Re: AMENDED COMMENTS for Vista West Performance Based Cluster Plat (LP-09-00001)

SUBJECT: Vista West Performance Based Cluster Plat CL-09-00001

RE: Vista West Performance Based Cluster Plat CL-09-00001

SCALE	SHEET
1"=100'	1 OF 2

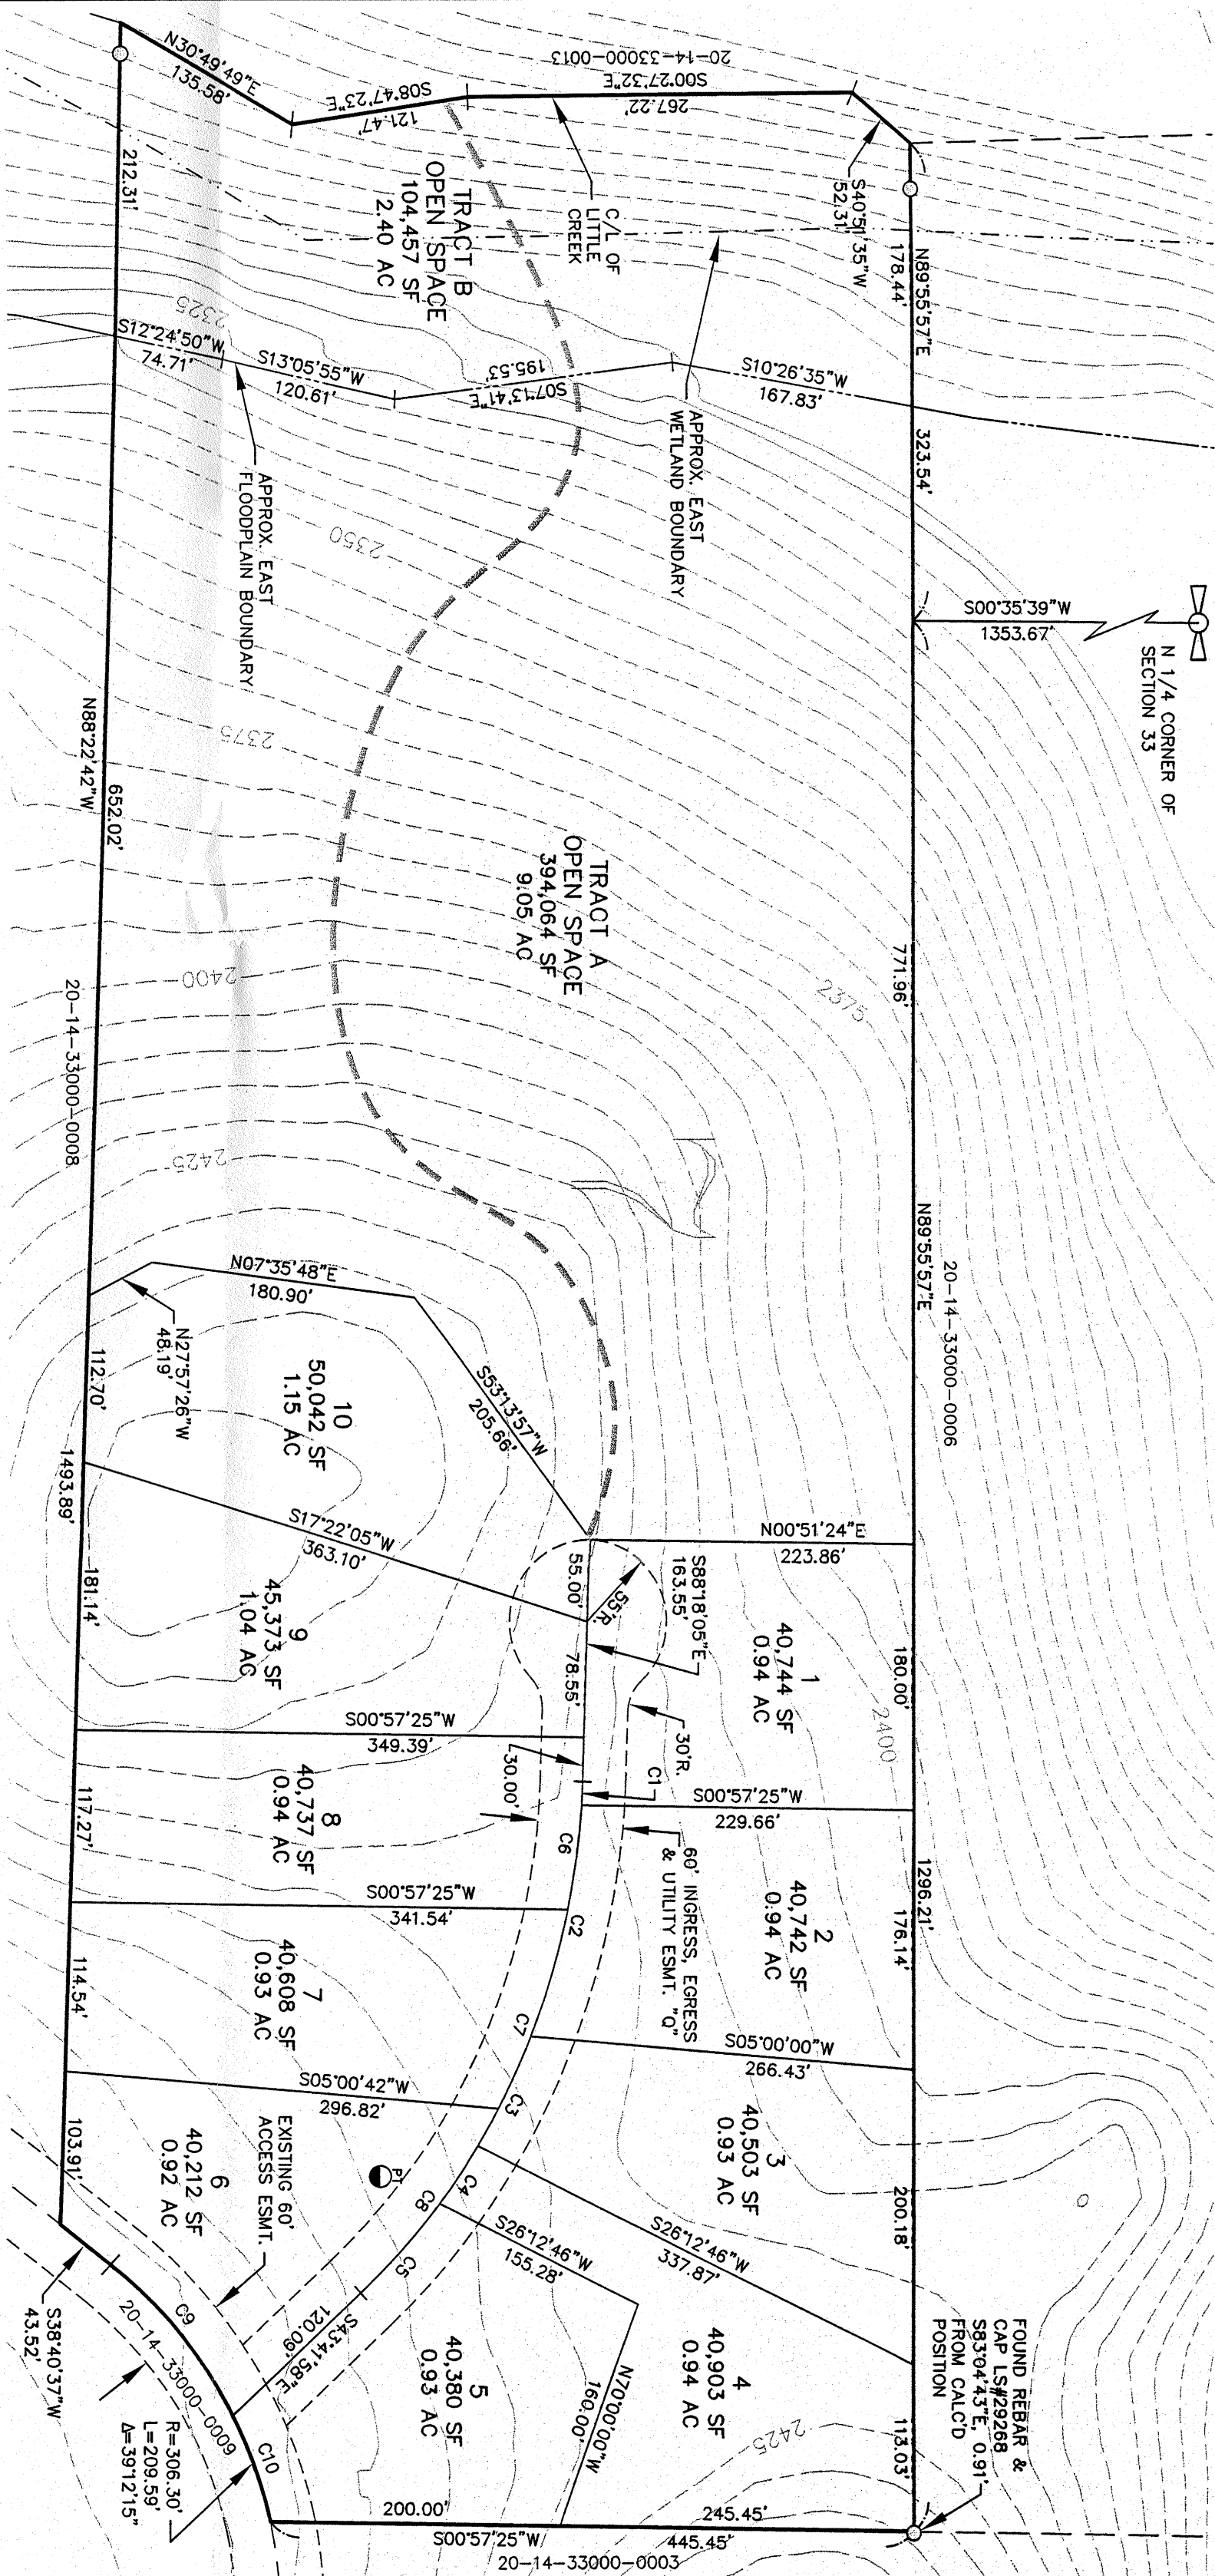
- No fire apparatus access lane shall have a slope greater than 12%. A Variance Permit will be required for any slopes or grades greater than allowed by County Code.

- "No Parking-Fire Lane" signs must be posted per Fire Marshal requirements on all cul-de-sacs.
- Secondary access is required, or each residence accessed off of the single access road shall be required to have sprinkler protection as required by the County Fire Marshal's Office, with all associated permits issued. The sprinkler requirement shall be noted as a plat note on the final plat.

3. Road Names: All roads shall be labeled on the plat.
4. Private Road Improvements: Access from the end of the County road to the cul-de-sac within the plat shall be constructed to meet or exceed the conditions of a High-Density Private Road that serves 15-40 tax parcels. See current Kittitas County Road Standards, 9/6/05 edition.
  - a. Access easements shall be a minimum of 60' wide. The roadway shall have a minimum width of 22', with 1' shoulders, for a total width of 24'.
  - b. Minimum centerline radius shall be 60'.
  - c. Surface requirement BST/ACP.
  - d. Maximum grade is 12%.
  - e. Stopping site distance, reference AASHTO.
  - f. Entering site distance, reference AASHTO.

5. Cul-de-Sac: A cul-de-sac turn-around having an outside right-of-way or easement diameter of at least 110 feet shall be constructed at the closed end of all dead-end roads serving 3 or more lots. The driving surface shall be at least 96 feet in diameter. Cul-de-sacs must also conform to the requirements specified by the 2009 International Fire Code. Contact the Fire Marshal regarding any additional cul-de-sac requirements.
